Submission No.			162	
Organisation Name or Name of Submitter			Kieran Smyth and Margaret McDonnell and others (121 Ballymun Road)	
Item No.	Section Ref.	Page No.	Observation Statement	TII Response
Letter Re: Application by Transport Infrastructure Ireland (TII) to An Bord Pleanála for the Railway (MetroLink Estuary to Charlemont via Dublin Airport) Order 2022				
1	1	1	While very supportive of the scheme overall, and its objectives as detailed in the application we would like to comment on certain details of the proposals, which raise concerns for us. Before doing so, we would like to take the opportunity of acknowledging and complimenting TII on its stakeholder engagement, and in particular its engagement of an independent engineering expert, RINA Consulting, to support residential stakeholders likely to be affected by the MetroLink works, which not only upholds the letter, but also the spirit of applicable Irish and EU law.	TII wish to thank you for your submission and your stated support for the delivery of MetroLink.

Submission No.	162
Organisation Name or Name of Submitter	Kieran Smyth and Margaret McDonnell and others (121 Ballymun Road)

ALBERT COLLEGE PARK INTERVENTION SHAFT. PLAN
SCALE 1:400

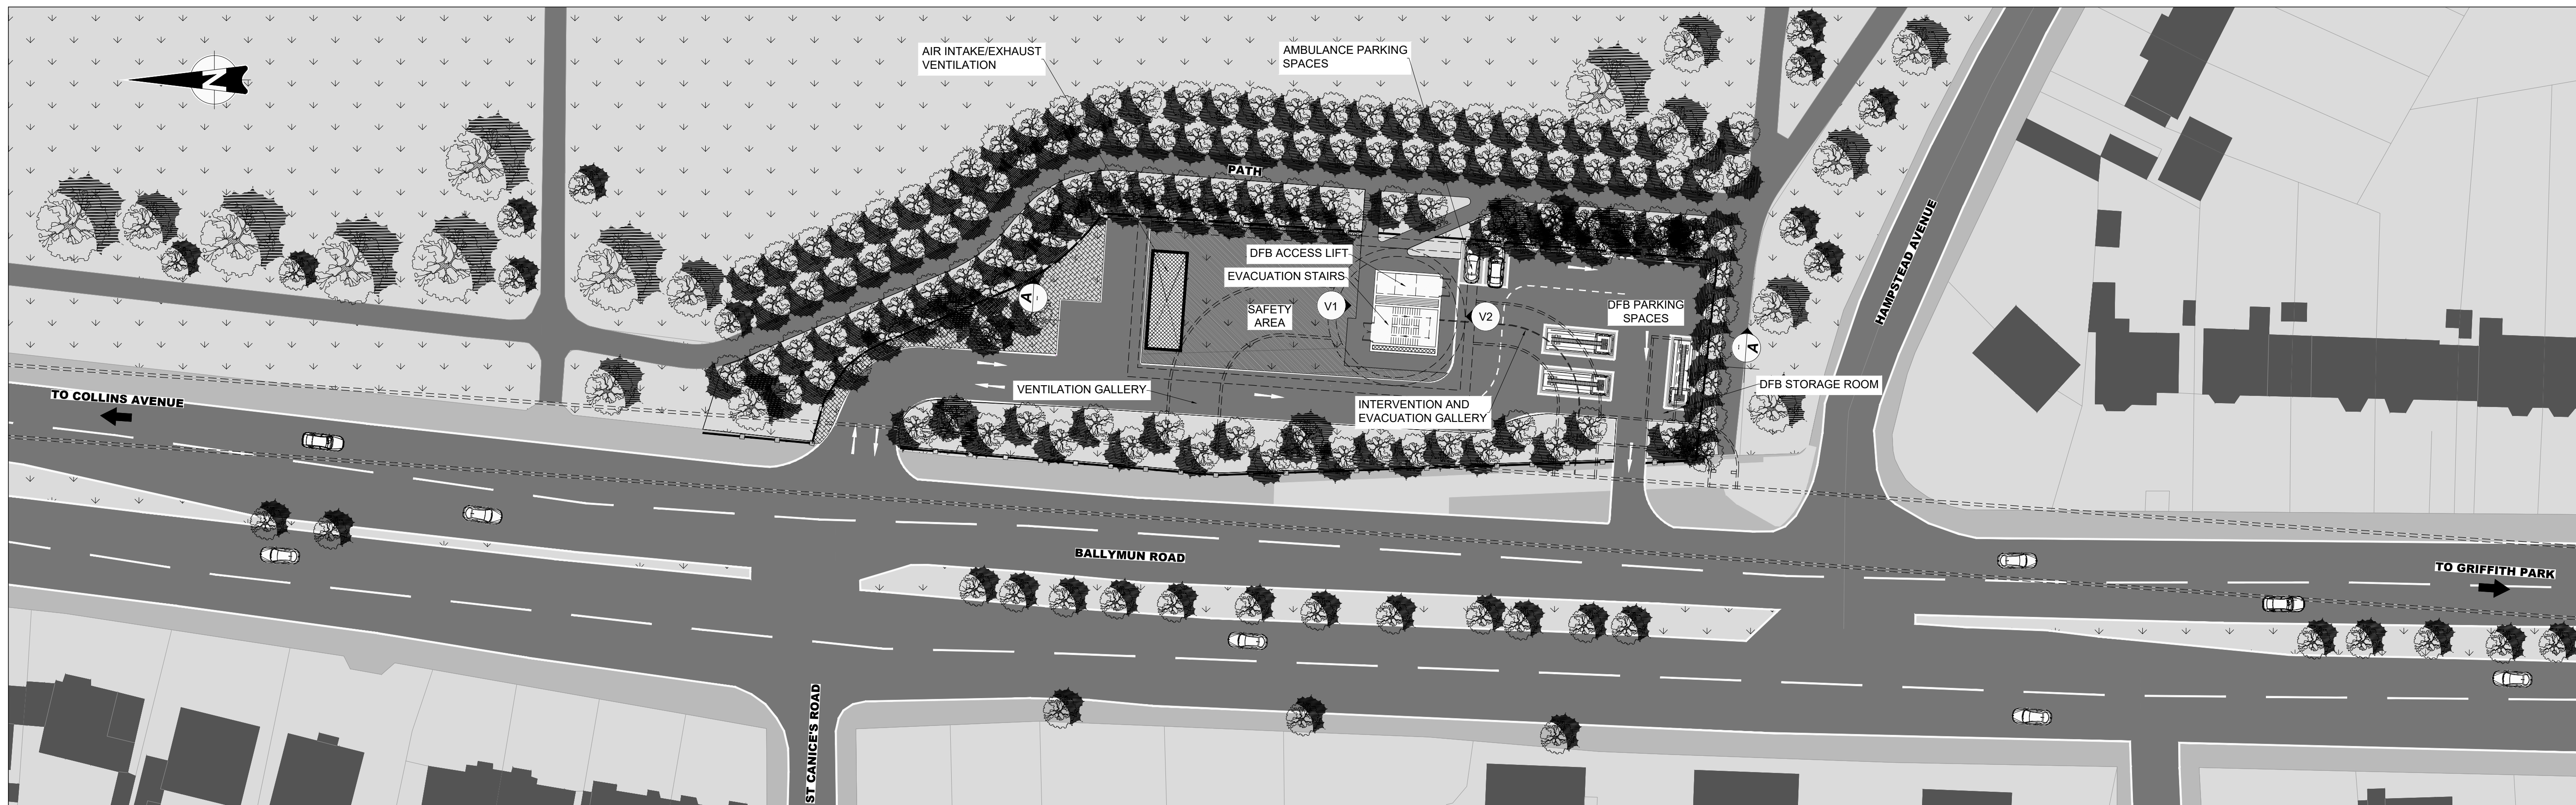
3	Albert College Park: Intervention Shaft- Protection and Preservation of the Park and Scale of Design Footprint	1,2	In our view the size and scale of the design of the Intervention Shaft (IS) proposed in the Albert College Park (ACP) will negatively impact not only the visual but the general amenity of the park by reducing the area of the park that is available for walking, and sports etc. We would therefore ask that an alternative to the current IS design, that would reduce its overall footprint, be fully considered. From some preliminary discussions with experts we understand that a suitable and effective IS could possibly be devised which would reduce its footprint using the kind of approach employed in the London Underground e.g. the new Elizabeth Line and Italian underground systems (see the red and yellow markings on the extract from the TII drawing of the IS attached - which illustrates in broad outline what the redesign and considerably reduced footprint of the IS might involve).	The design for the ACP Intervention Shaft has been developed having regard to the operational requirements, submissions received and detailed discussions with Dublin Fire Brigade and other stakeholders with regard to the site layout. The landscaping has been developed to mitigate any visual impact. Overall, MetroLink is taking a small proportion of the park with the walkways and the football pitches will be reinstated on completion of construction. The EIA Chapter 27, Landscape & Visual and Chapter 15, Biodiversity set out the assessment of the potential impacts at Albert College Park and the proposed mitigation, while Appendix A8.18 details the engagement that has taken place with Dublin Fire Brigade. TII will work with the subsequent detailed designer to provide optimisation if feasible such that residual impacts are mitigated so far as is reasonable practicable.

4	Albert College Park: Intervention Shaft- Protection and Preservation of the Park and Scale of Design Footprint	2	Key issues to be considered here are: -reducing the number of parking places and placing the ones that remain onto a grass verge at the edge of the Ballymun Road as a new emergency vehicle only layby, - moving the Air Intake/Exhaust Ventilation structure to the main building structure for the stairs and lift: while it would make that building a little larger it would significantly reduce the 'technical footprint' of the site overall (as long as the equipment rooms below ground as currently designed remain as is and perhaps are grassed over).	Please refer to response item (3) above in relation to the design and sizing of the Intervention Shaft at Albert College Park. As set out within the EIA Chapter 4 section 4.17.5, a one way system for entry from and exit to the R108 has been provided for Dublin Fire Brigade, alongside required parking space for vehicles by the intervention shaft, both following discussions with Dublin Fire Brigade regarding their requirements. Further details are provided on slide 84 of 89 on RO Submission: Structures Details Book 3 of 3 Other Line wide Structures Fingal County Council and Dublin City Council. The reasoning supporting the proposed location, layout and operation of the Emergency Shaft at Albert College Park is detailed within Appendix A8.16.

5	Albert College Park: Intervention Shaft- Protection and Preservation of the Park and Scale of Design Footprint	2	Another issue to be examined in terms of reducing the footprint of the IS might be to limit it to a shaft head and the subsurface buildings with a clear paved road from the revised IS to the main road in a straight line. That would omit the parking area in particular and having both an access and an exit road). This would be done on the basis of the Ballymun Road being closed in the event of an emergency, which we understand would be a recognised approach successfully used in the London Underground system.	Please refer to responses (3,4) above in relation to the required space for emergency vehicles, following consultation with Dublin Fire Brigade.

Submission No.		162		
Organisation Name or Name of Submitter		Kieran Smyth and Margaret McDonnell and others (121 Ballymun Road)		
Item No.	Section Ref.	Page No.	Observation Statement	TII Response
6	Albert College Park: Intervention Shaft- Protection and Preservation of the Park and Scale of Design Footprint	2	While these are technical matters which would require detailed expert consideration we have seen no convincing analysis and rationale from TII for the proposed scale of the IS footprint in the ACP. We would ask that An Bord Pleanála as a preliminary matter in advance of the finalisation of the Railway Order require TII to give further consideration, in consultation with other relevant bodies, with a view to reducing the design of the IS in the ACP to the minimum necessary for a suitable and effective IS in order to better protect the amenity of the ACP.	Please refer to responses (2, 3 and 4) above in relation to the rationale for the location and size of the ACP Intervention Shaft, which takes cognisance of the requirements set out by Dublin Fire Brigade and the feedback from public consultations. TII will work with the subsequent detailed designer to provide optimisation, if feasible, such that residual impacts are mitigated so far as is reasonable practicable.
